**TOWN AND COUNTRY PLANNING ACT 1990 – SECTION 73: APPLICATION FOR VARIATION OF A
CONDITION FOLLOWING GRANT OF PLANNING PERMISSION: A/122/19/OUT – LAND OFF ARUNDEL
ROAD, ANGMERING**

This submission is seeking to substitute the approved proposed secondary access drawing 2020-F03 Rev B with amended drawing C86473-JNP-66-XX-SK-T-7007-P02 which provides an alternative technical solution for the secondary access road that is viable and deliverable to serve the land identified as the Employment/Commercial Centre within the outline planning permission.

Title:
**Commercial Access - General Arrangement
1no Footway, North Side**

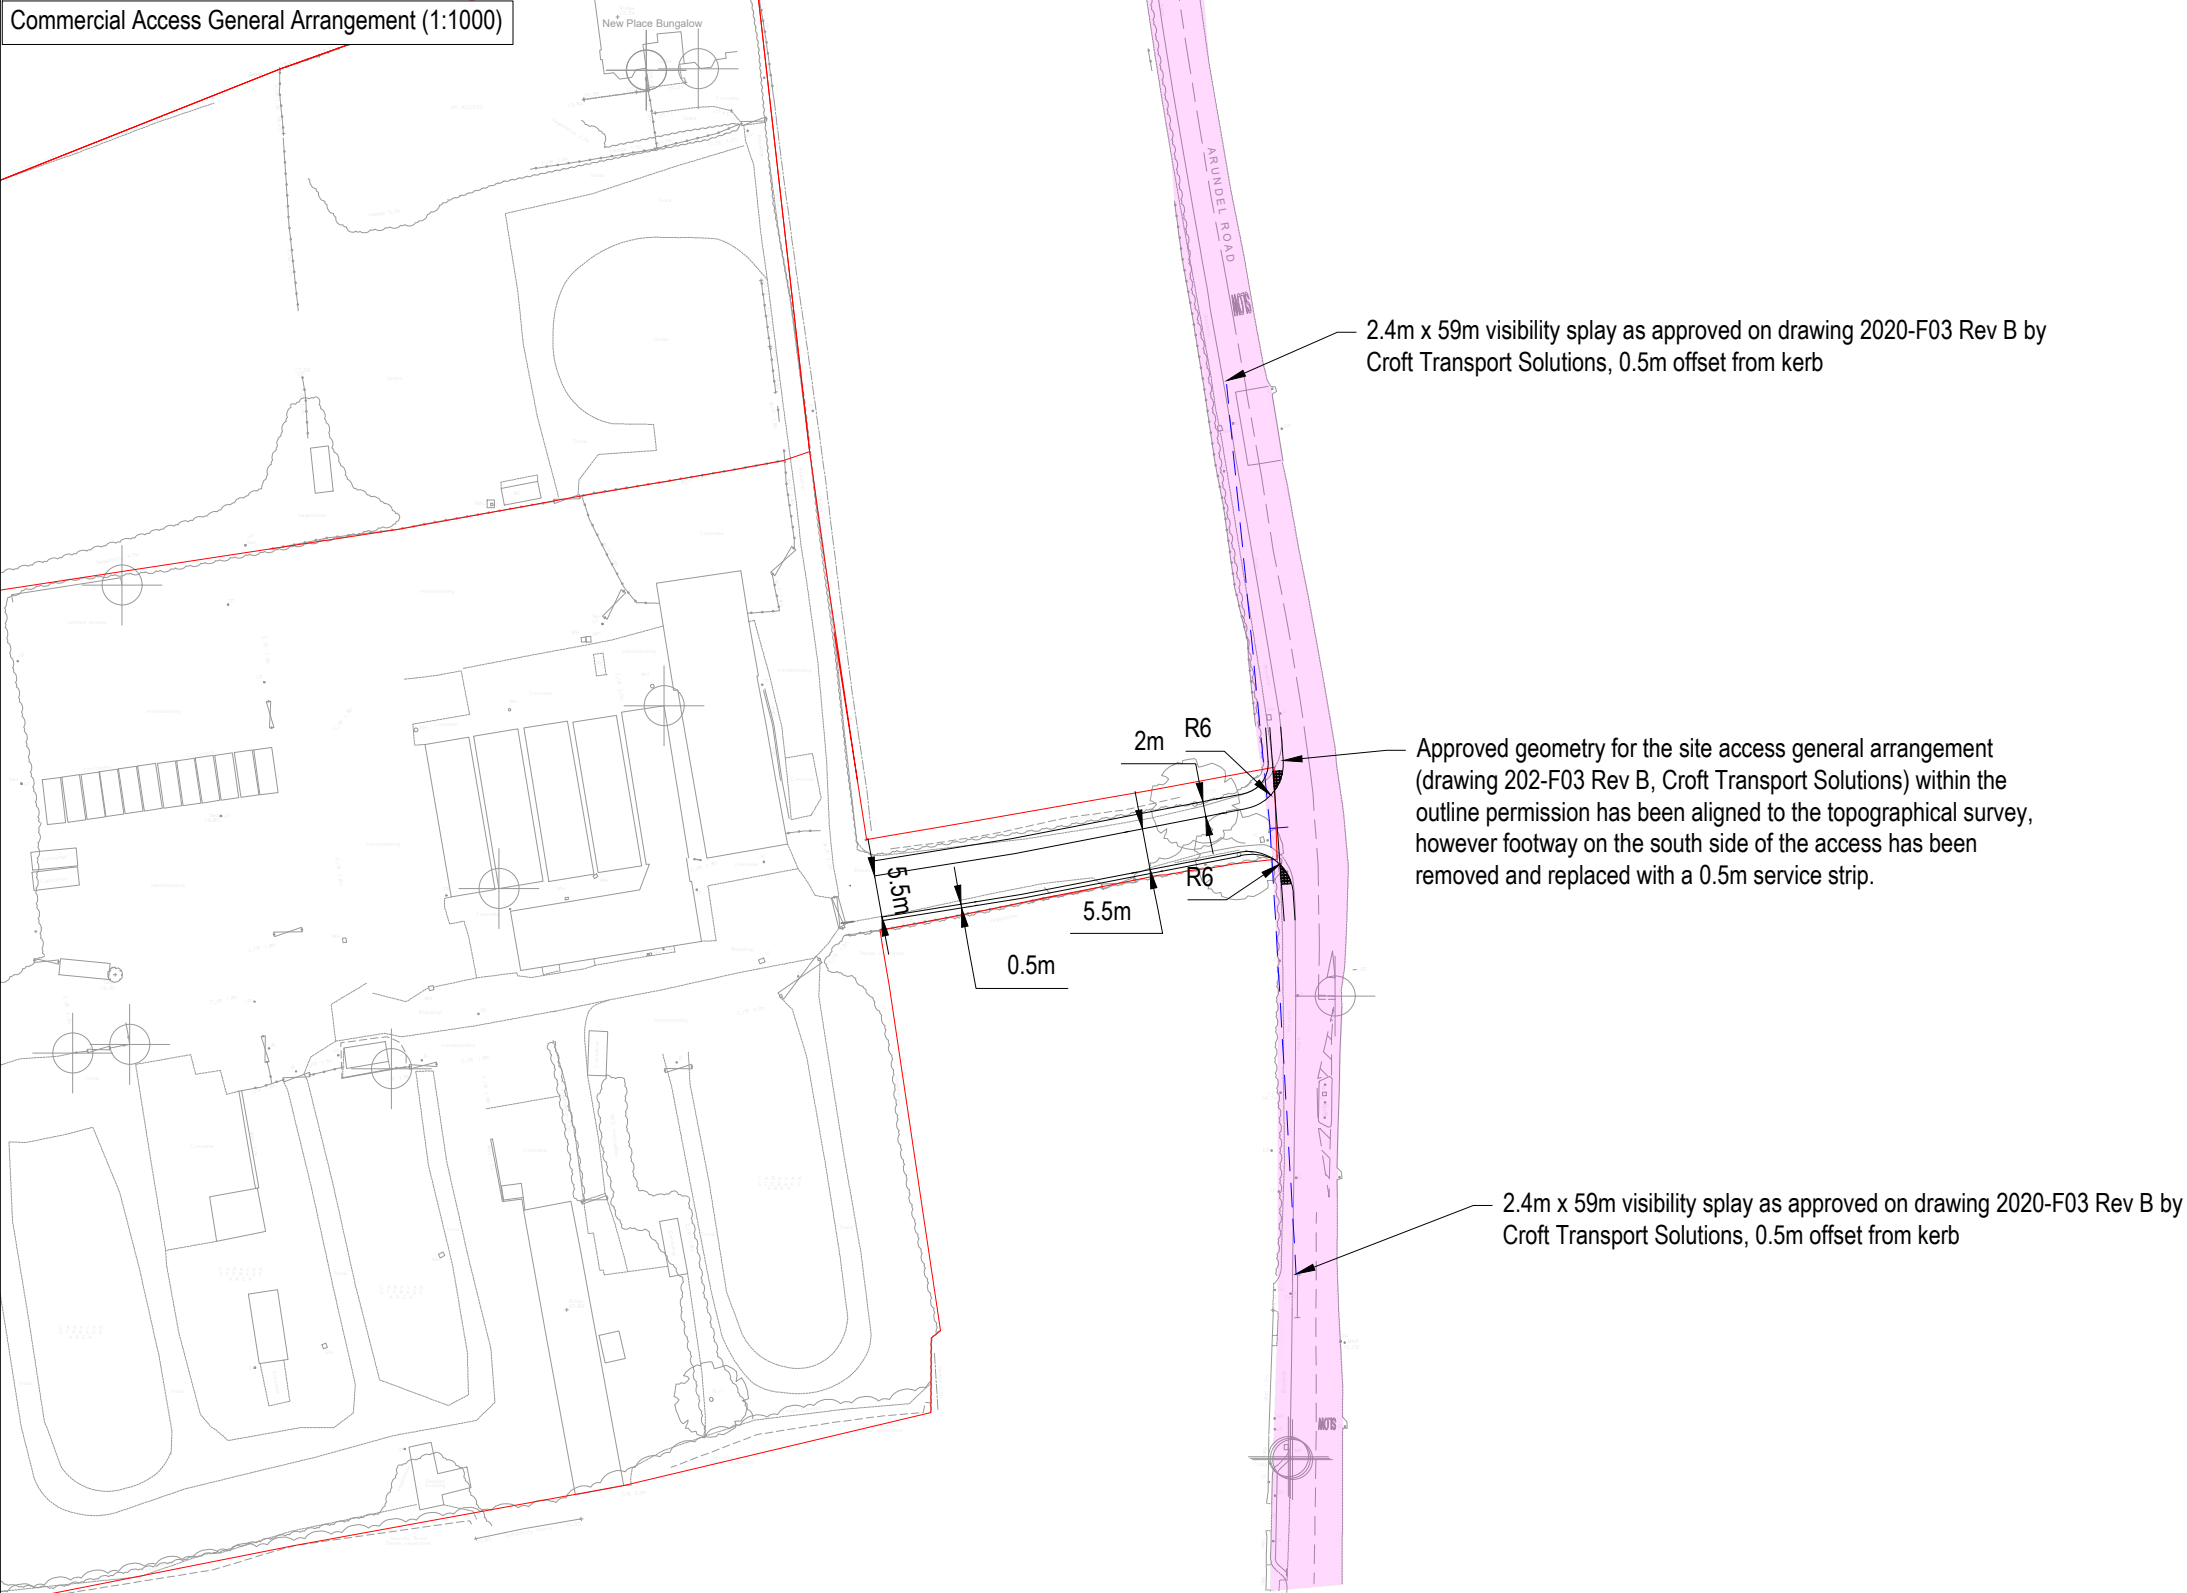
In light of the requirement to amend the technical details associated with the approved secondary access into the site (drawing reference: 2020-F03 Rev. B), we wish to vary the relevant conditions that require the access to be delivered in line with the approved drawings to reflect the amended access arrangements.

Drawing Number C86473-JNP-66-XX-SK-T-7007-P02 – Commercial Access – General Arrangement 1no Footway, North Side

No part of the Employment/Commercial Centre shall be first occupied until such time as the vehicular access serving the development has been constructed in accordance with the details shown on **Drawing Number C86473-JNP-66-XX-SK-T-7007-P02 – Commercial Access – General Arrangement 1no Footway, North Side.**
